From: Liz Annalls [REDACTED]
Sent: 02 March 2022 10:26
To: Planning.Responses <Planning.Responses@arun.gov.uk>
Subject: RE: Planning Consultation on: Y/10/22/PL

Application No: Y/10/22/PL
Site Address: Land to the south of Ford Lane and east of North End Road Yapton BN18 ODS
Description of Works: Erection of 15 No dwellings (including 4 No affordable units) with associated access, parking, landscaping, drainage and public open space (additional units to those approved under application Y/123/21/PL). This application may affect the setting of a listed building, affects the character & appearance of the Church Lane Conservation area, affects a Public Right of Way and is in CIL Zone 2 and is CIL Liable as new dwellings.

Liz Annalls
Environment Officer
Environmental Protection
Chichester District Council

Figure 3.1: Phase 1 habitat map

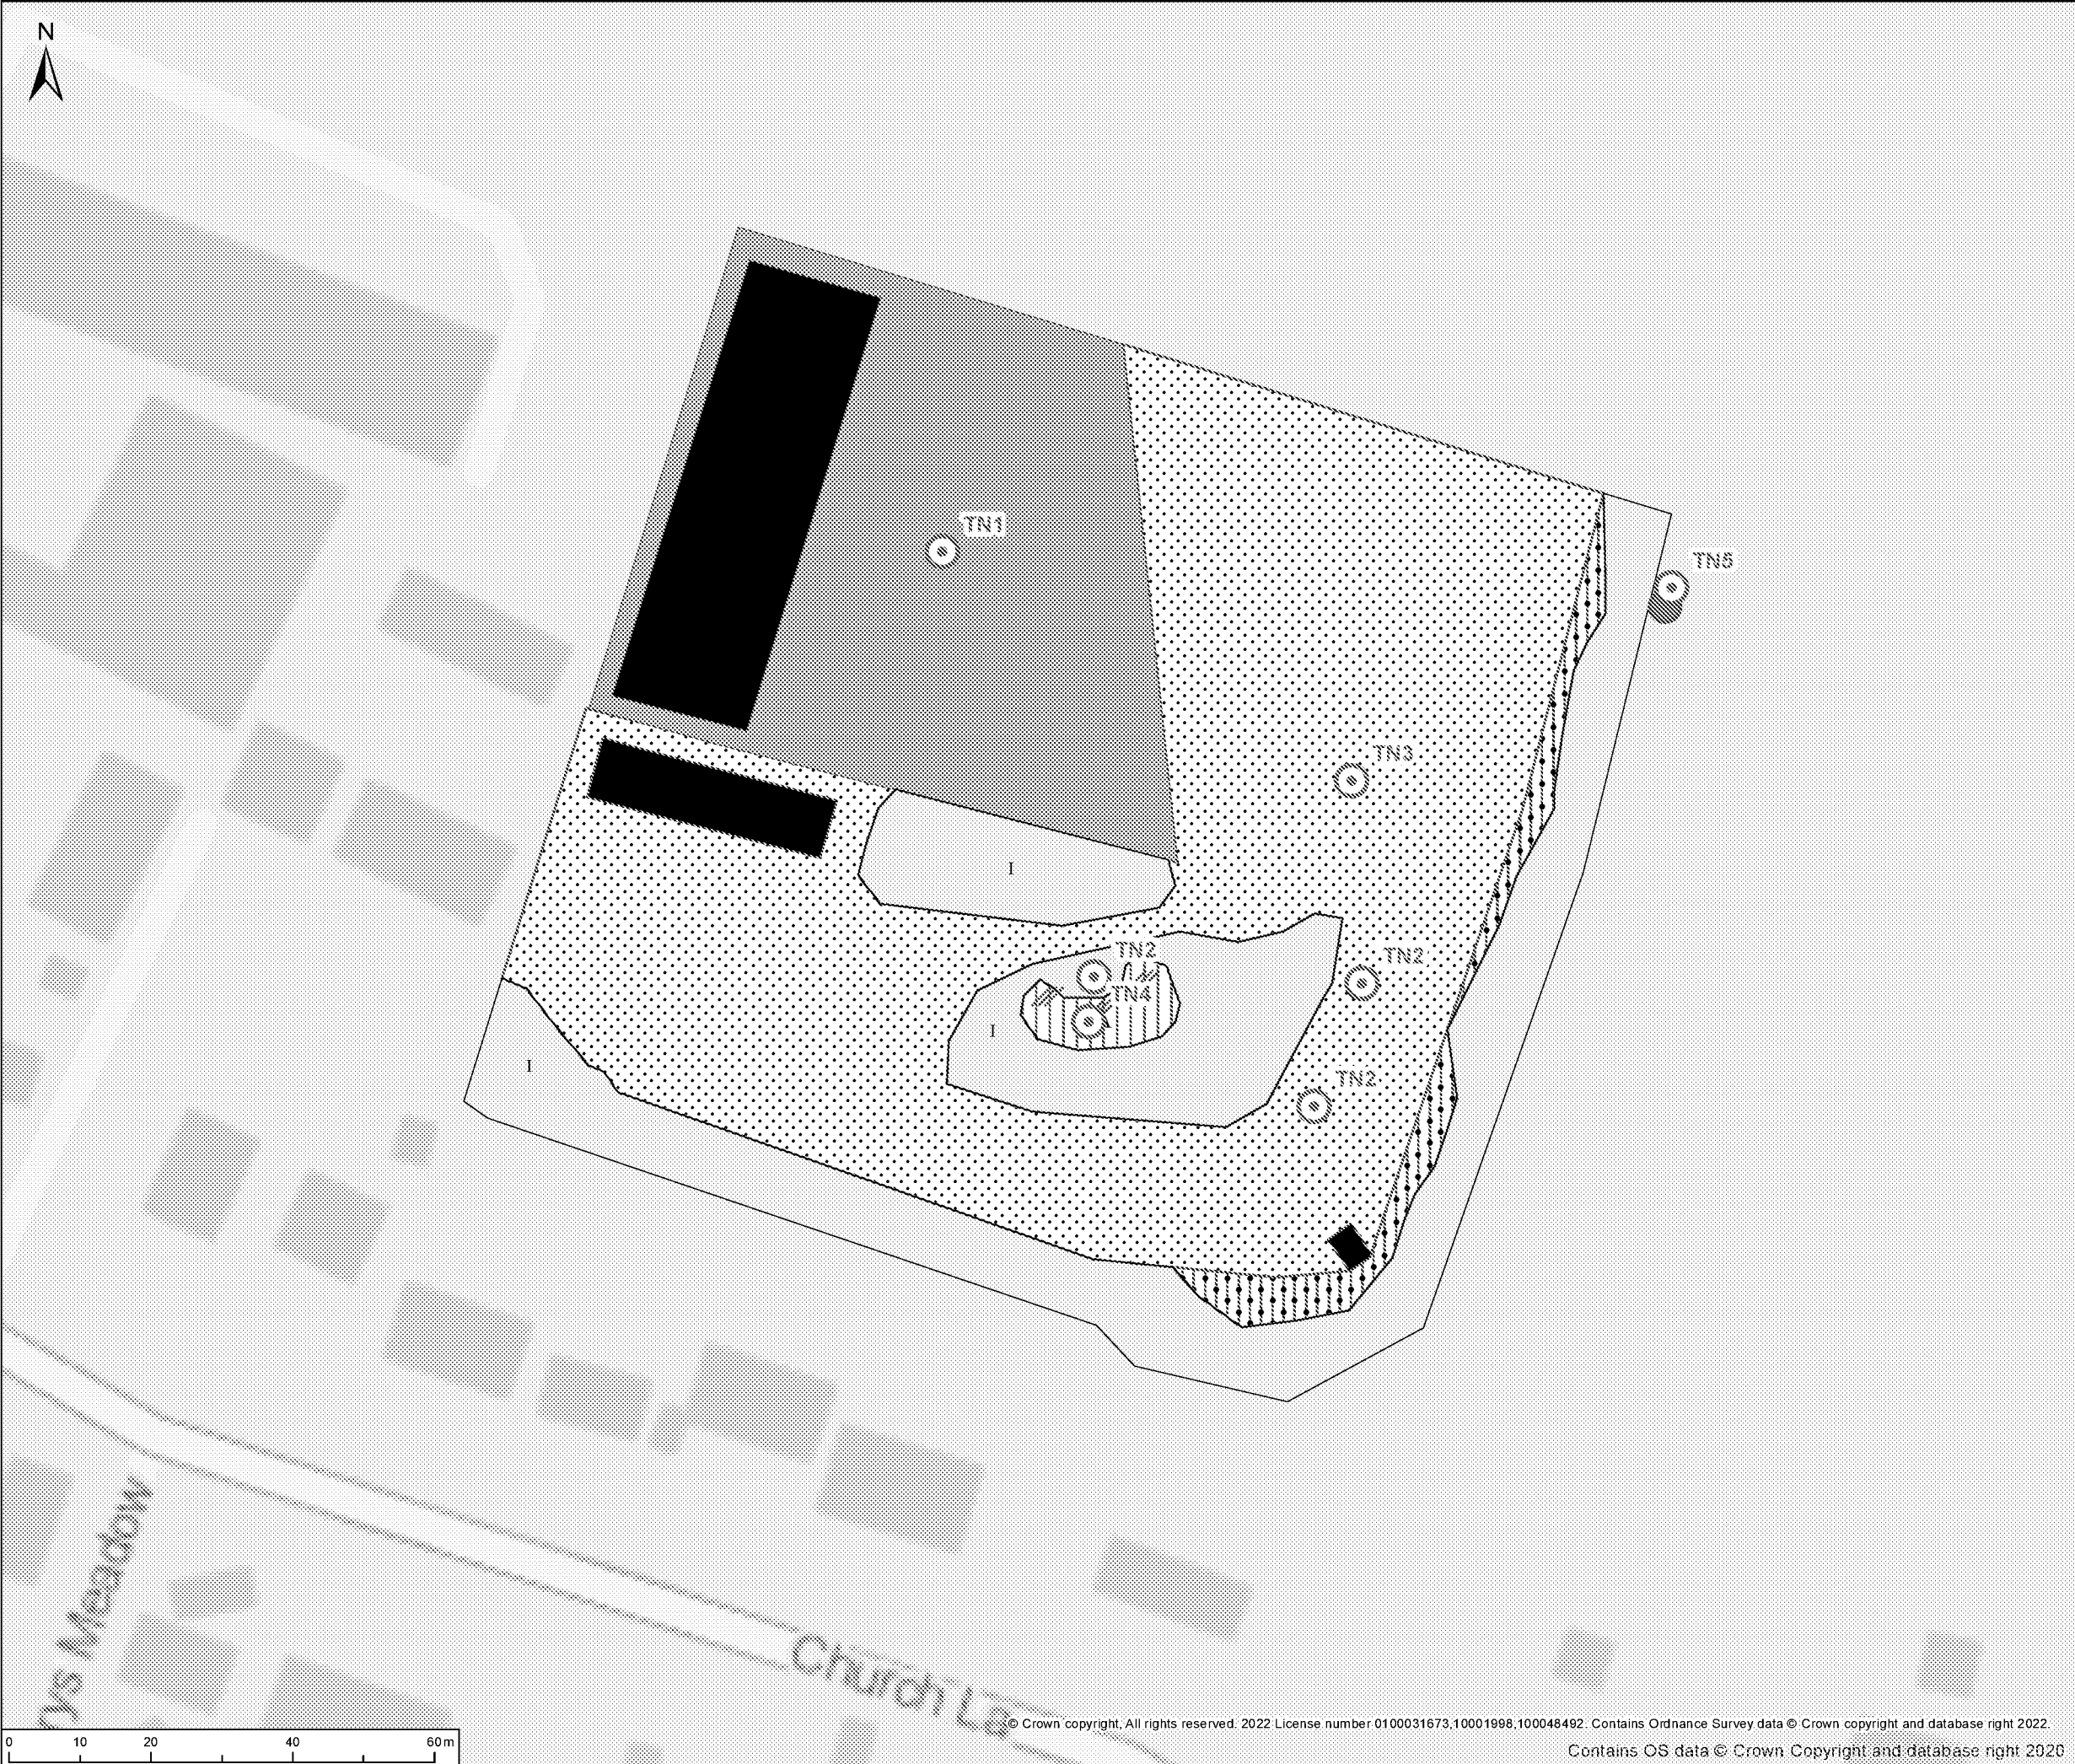
As detailed within the Ecological Appraisal (Feb 2022) the Oak tree on the eastern boundary of the site has moderate potential for roosting bats. Due to this, the Oak tree must be retained and protected from harm. If plans change and any works are required within close proximity to the tree or the tree needs to be removed, then further bat survey work would be required for this.
